Application for Planning Permission
Town and Country Planning Act 1990

Extension to muck store to provide fodder storage - see attached v. map

RE: Extension to muck store to provide fodder storage
 AT: Cragg House Farm, Chipping

Project Number,
230/101

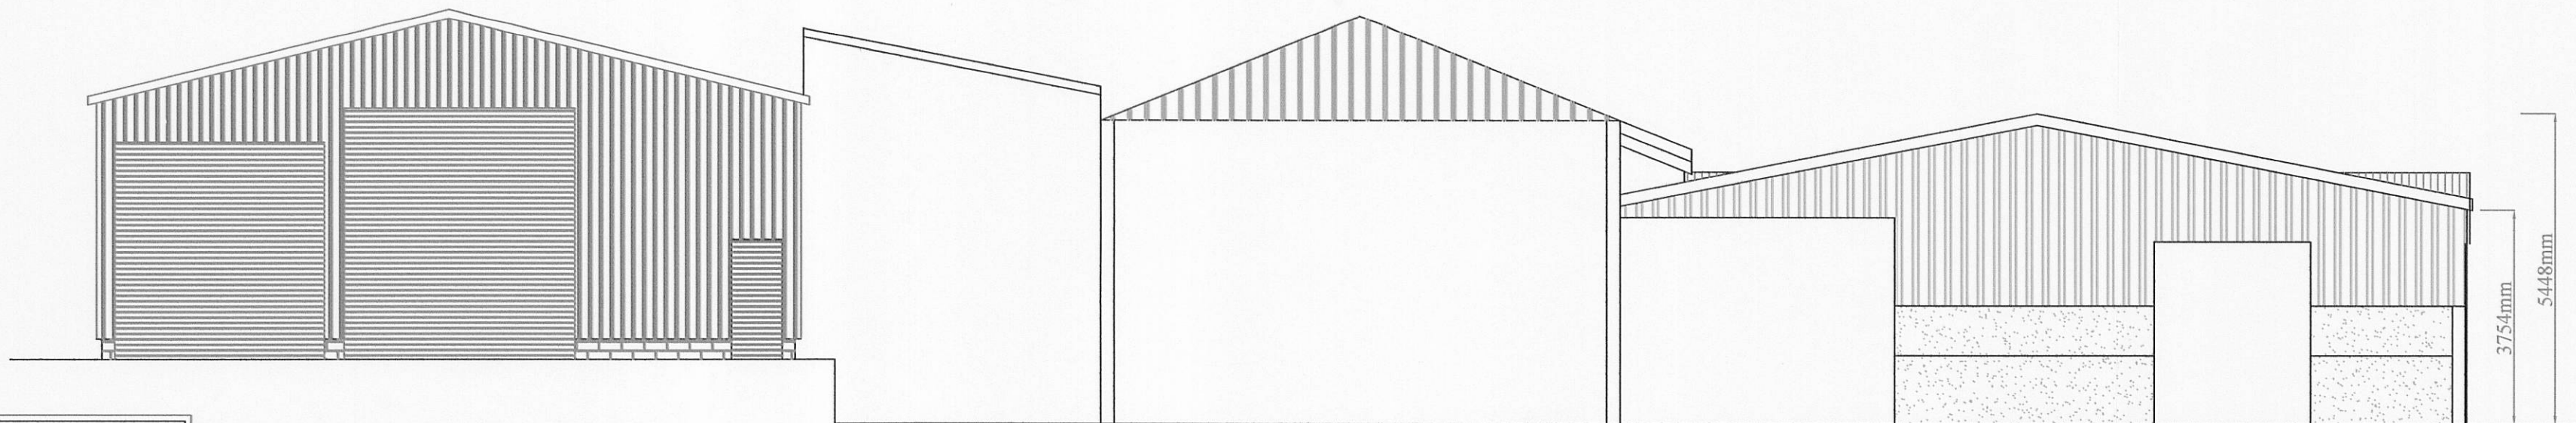
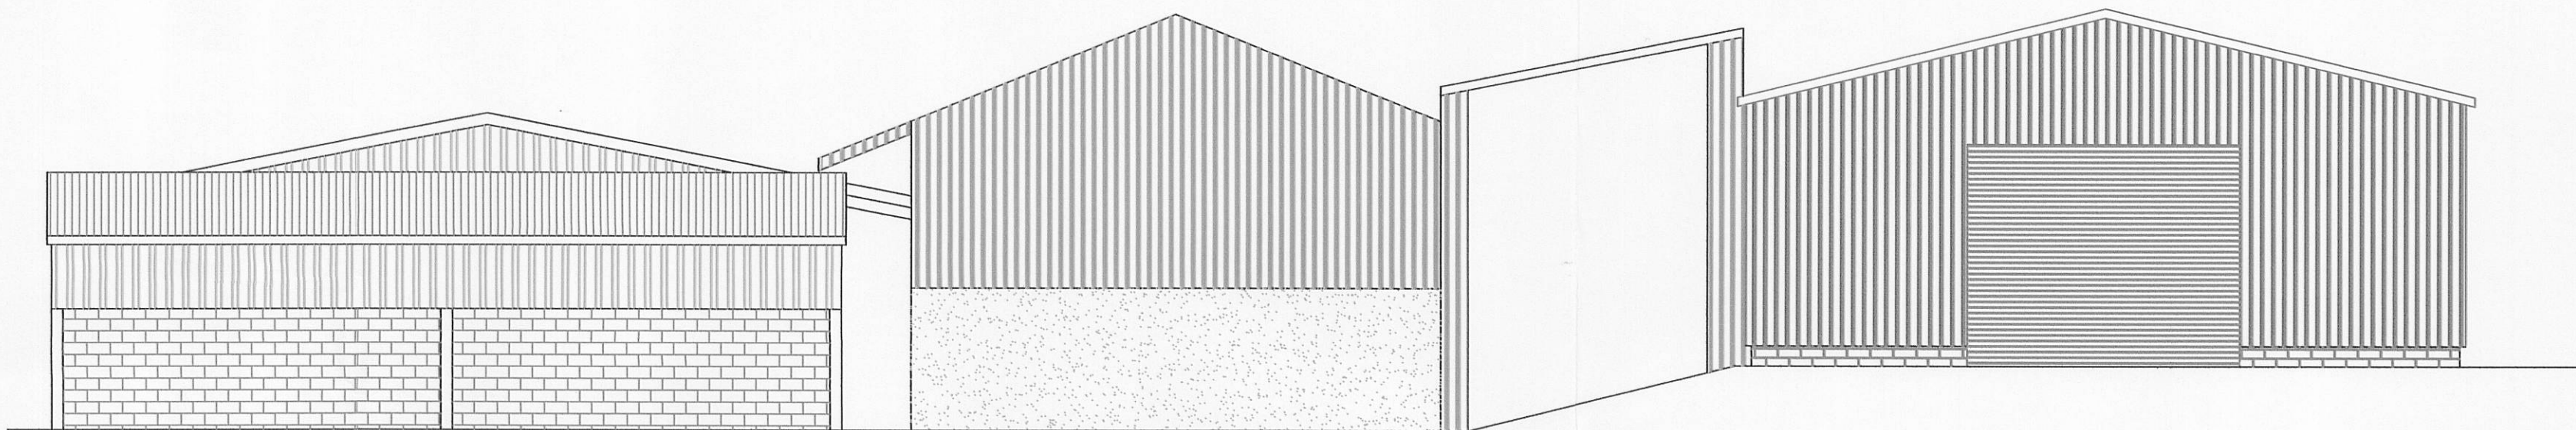
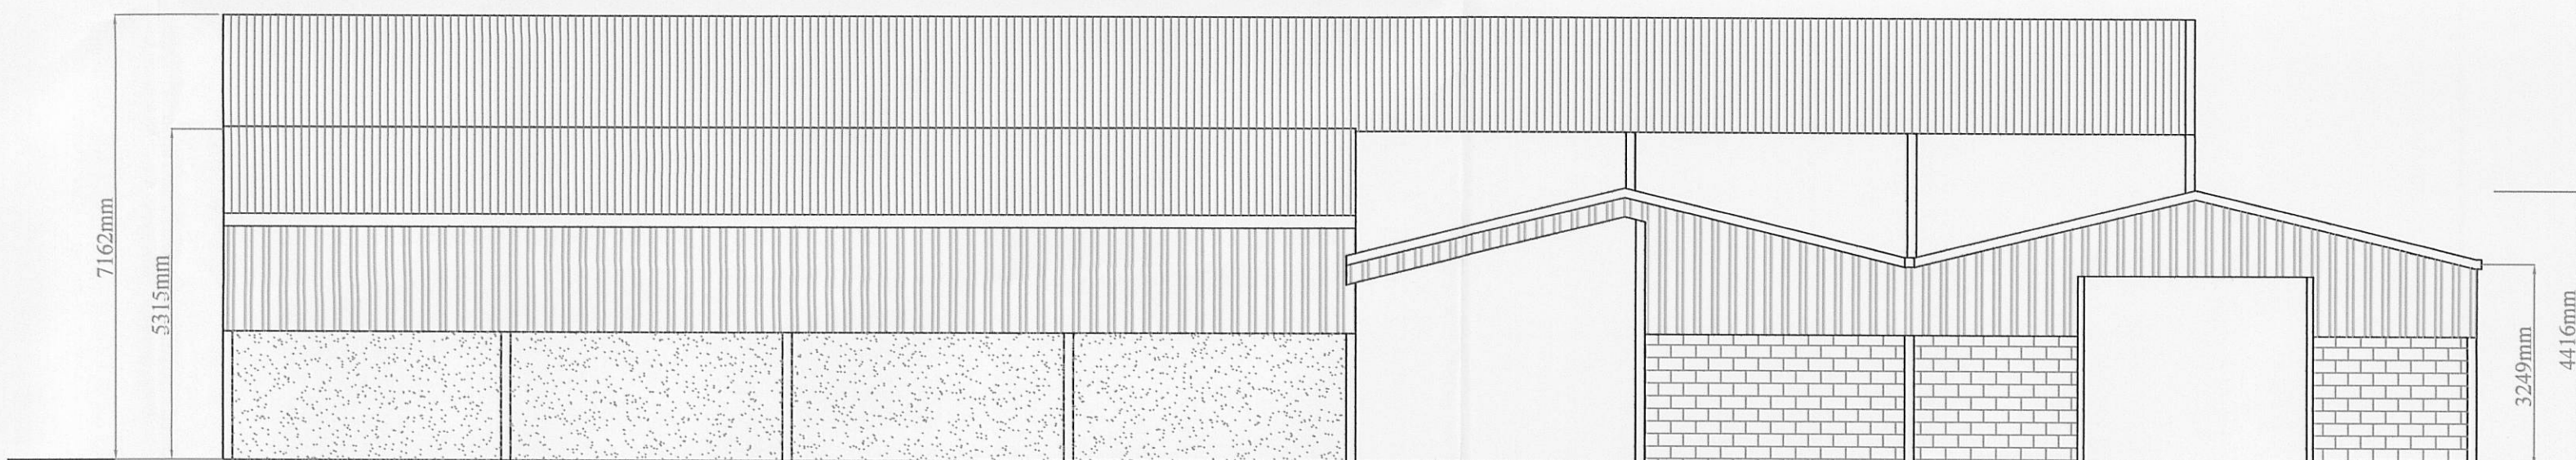
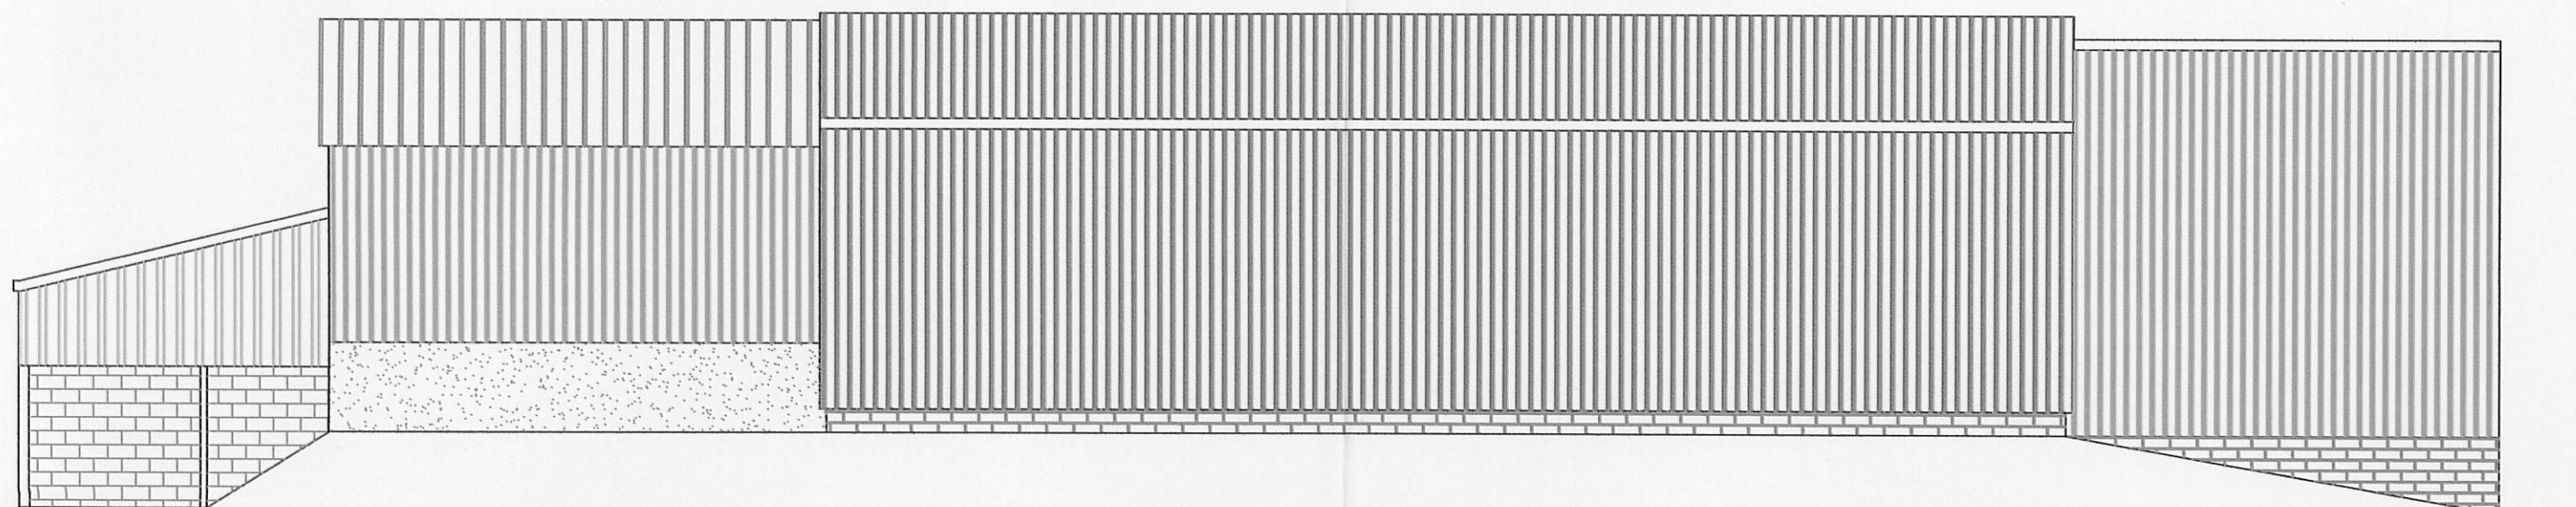
- I think the elevations on drawing 230/101 have been labelled incorrectly - I think they should be labelled as 'existing' ✓
